**RMS AND TfNSW CONSULTATION MEETING MINUTES
STATE SIGNIFICANT DEVELOPMENT (SSD) 9210
PROPOSED SAINTS PETER AND PAUL CHRISTIAN PRIMARY SCHOOL
17-19 KOVOVICH PLACE, CECIL PARK (LOT 2320 & 2321 DP 1223137)**

Meeting Date: 12 April 2018

CLIENT / Project:
Saint Peter & Assyrian Primary School

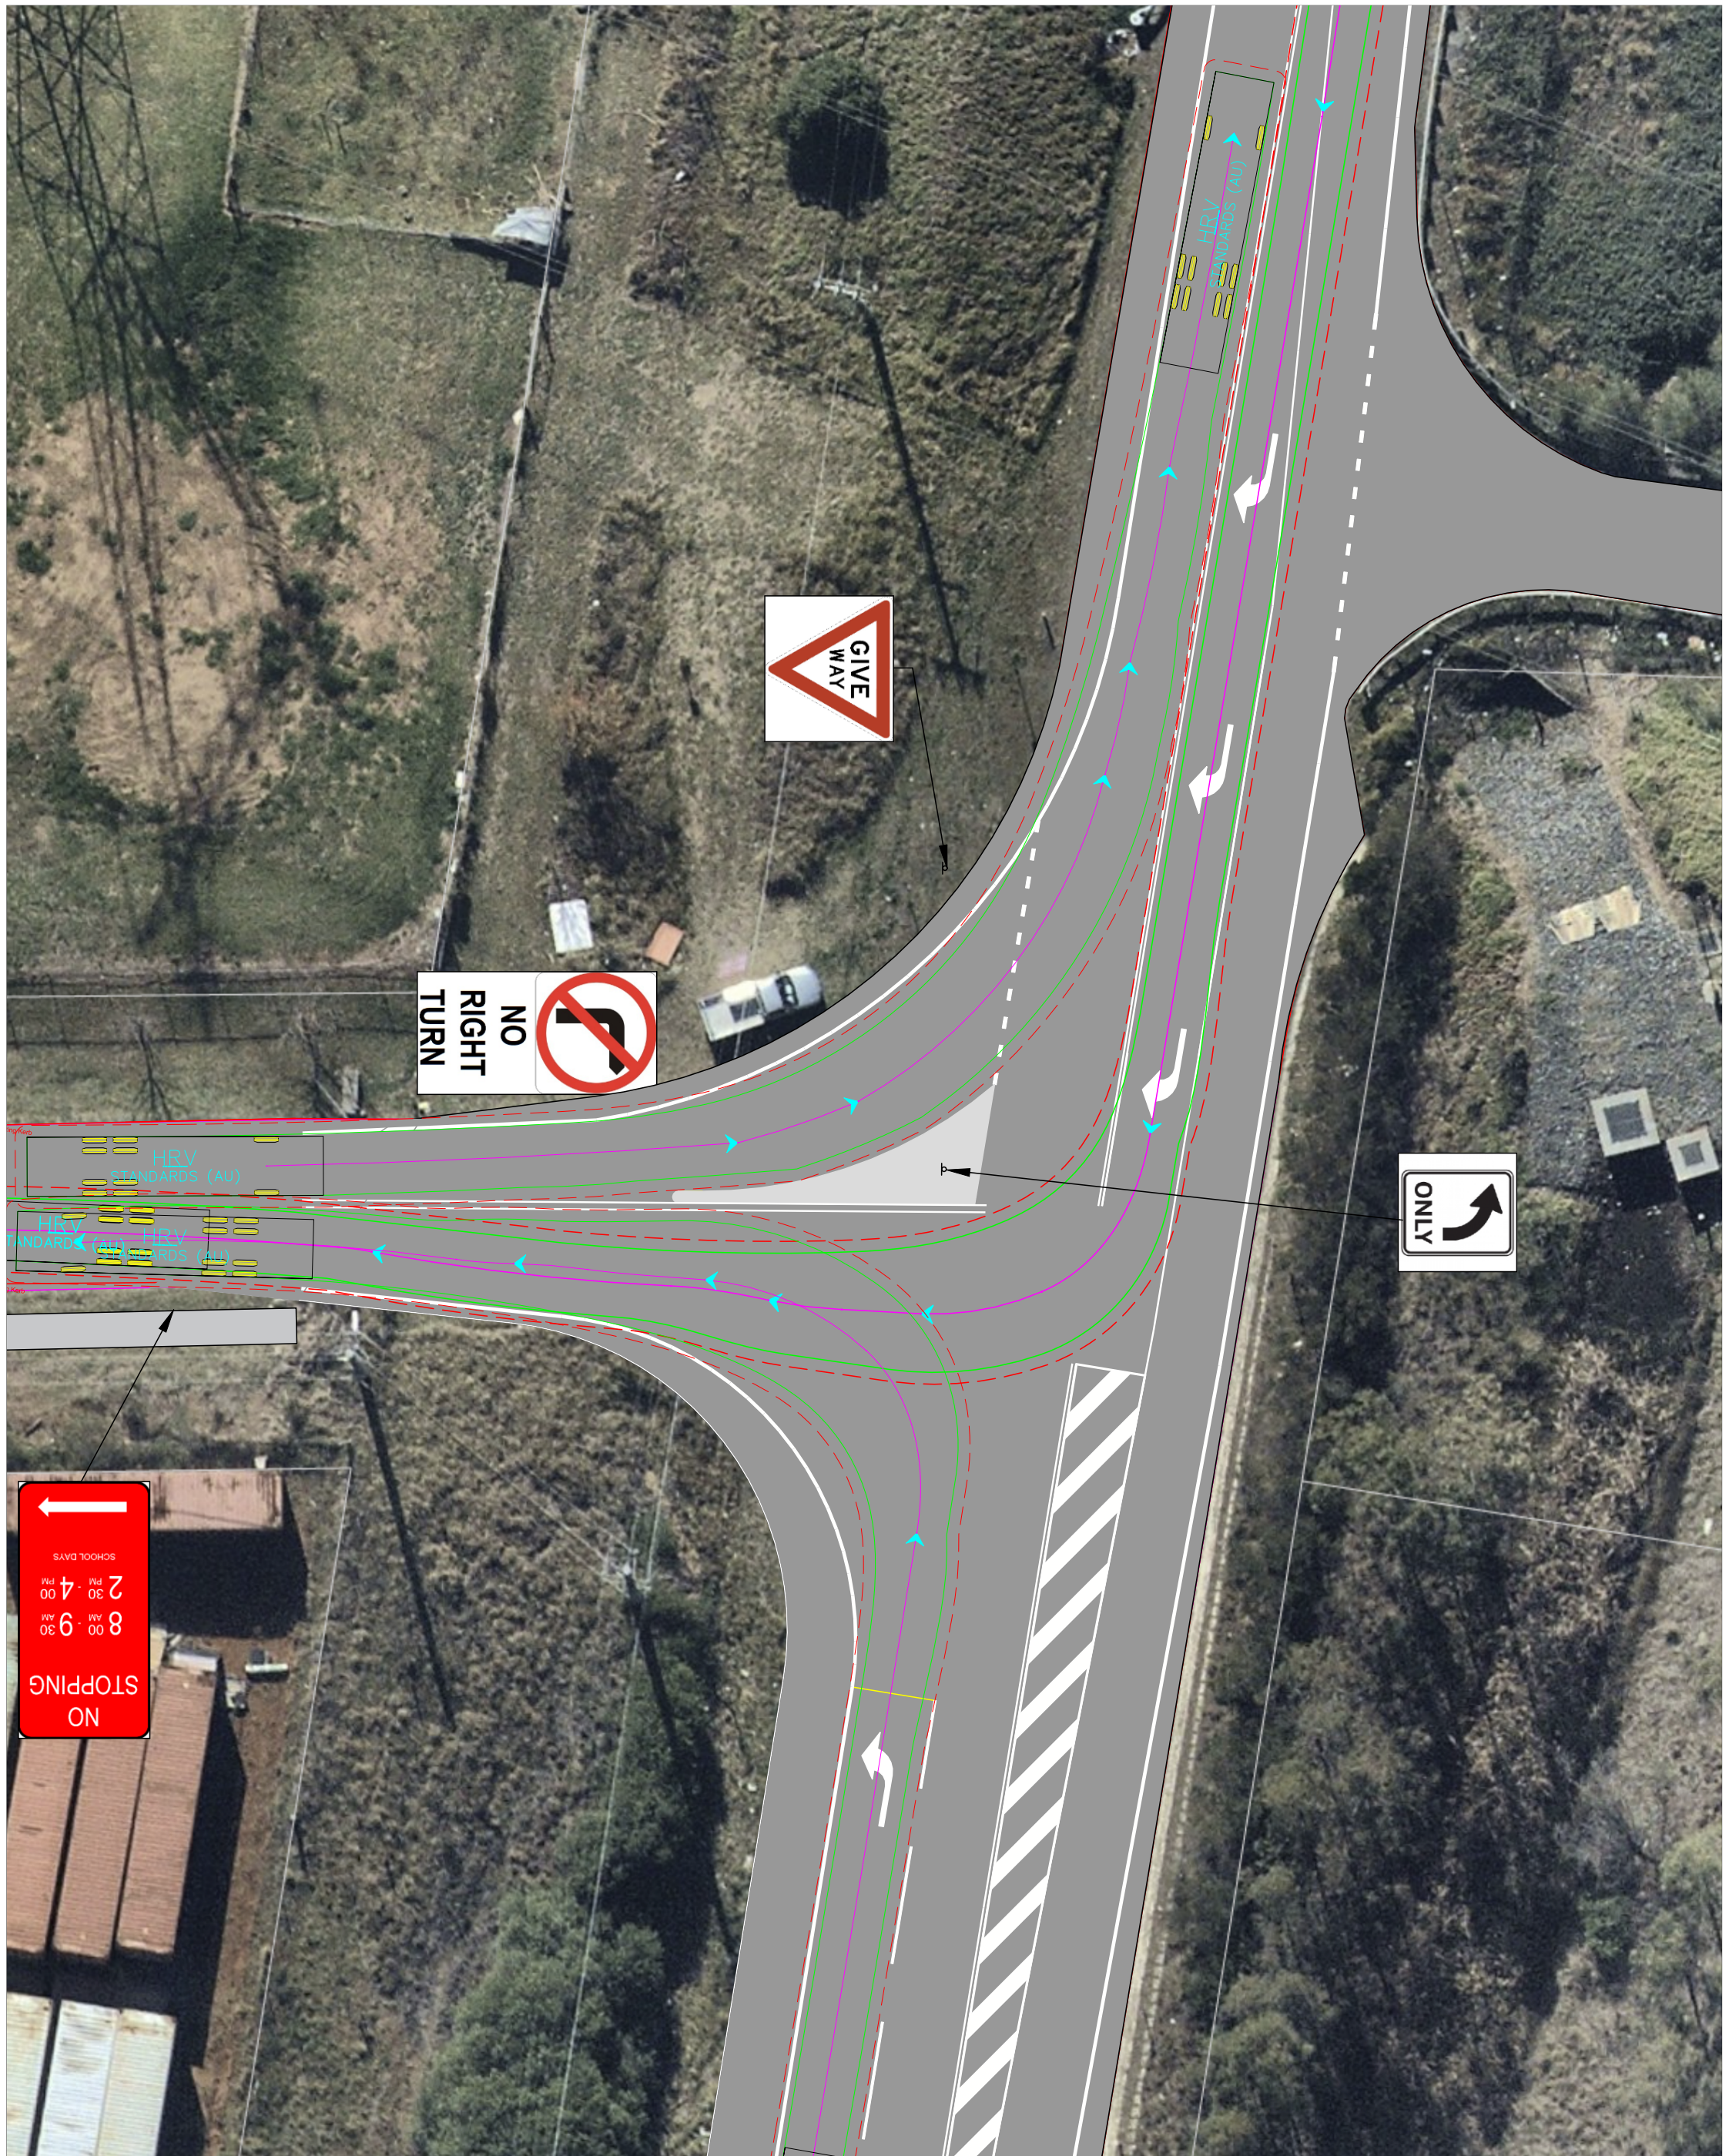
- The meeting focused on initial considerations based on review of the preliminary Masterplan.
- Bus access is limited; Kosovich Place is a cul-de-sac and the turning head will need to be assessed by swept path analysis to confirm whether it can accommodate a bus completing a u-turn.

Revision	Date	Details
A	12/07/2018	
B	20/07/2018	Storage length and road width shown
C	05/02/2020	Left Turn Decel Added

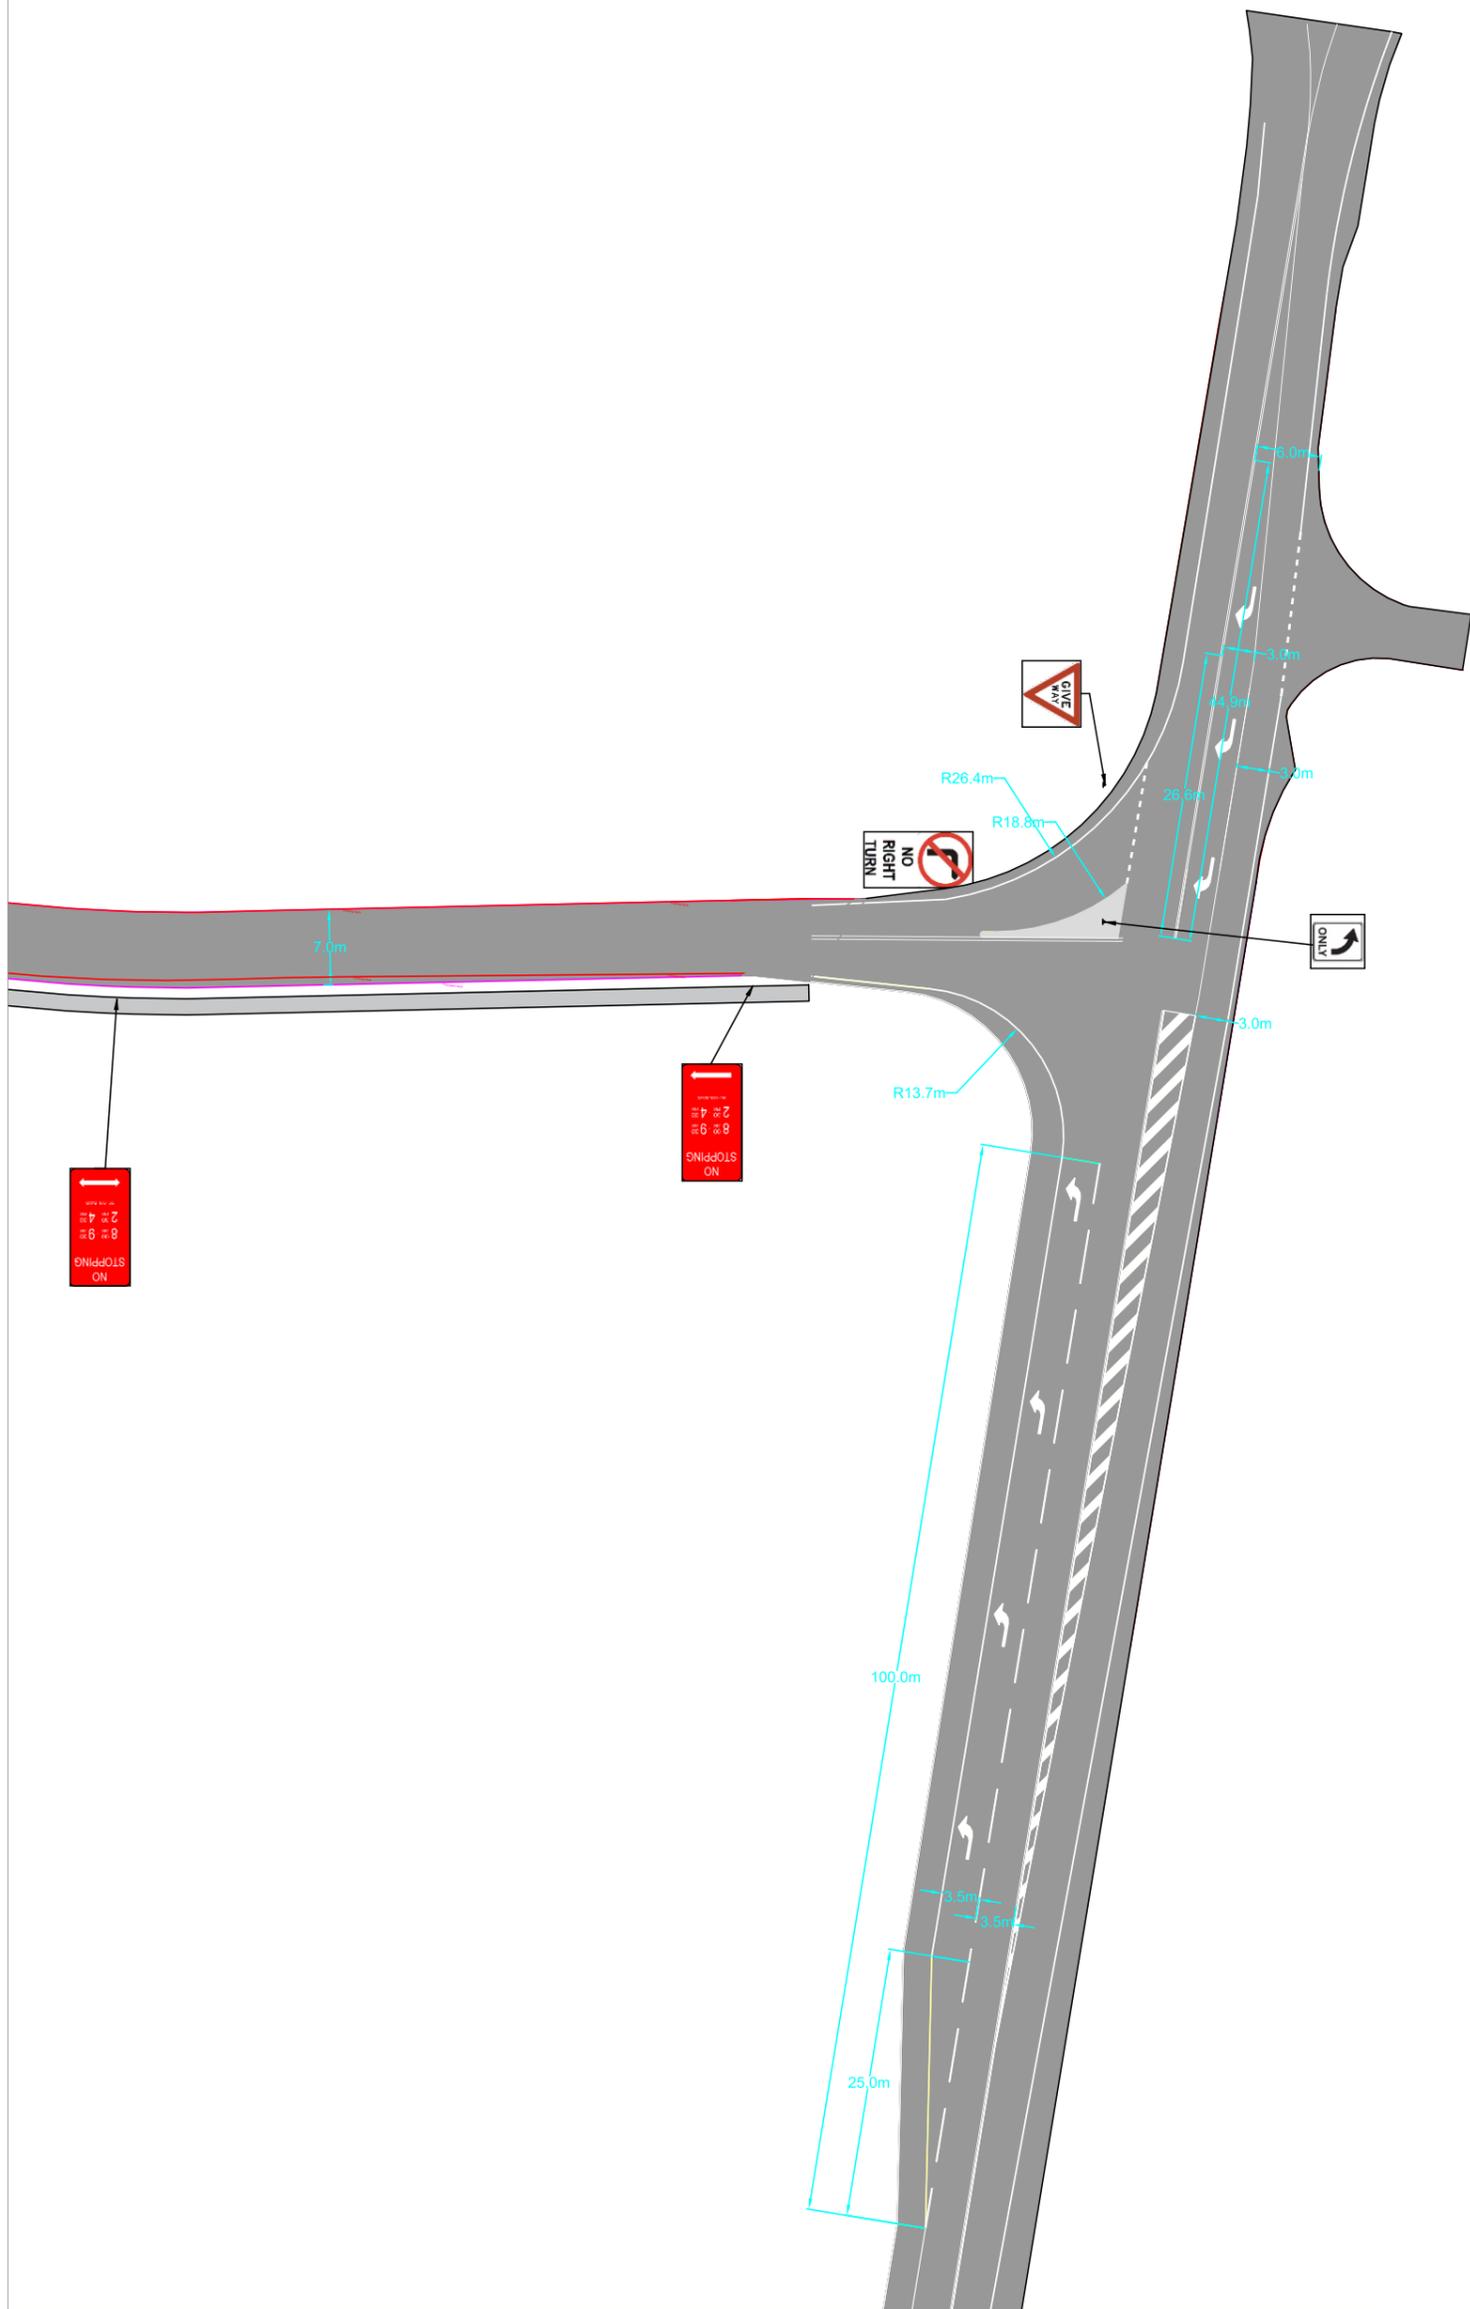
- It was considered that there may potentially be an issue with safety and/or capacity at the intersection of Kosovich Place and Wallgrove Road, particularly associated with the right-turn movement out of Kosovich Place.
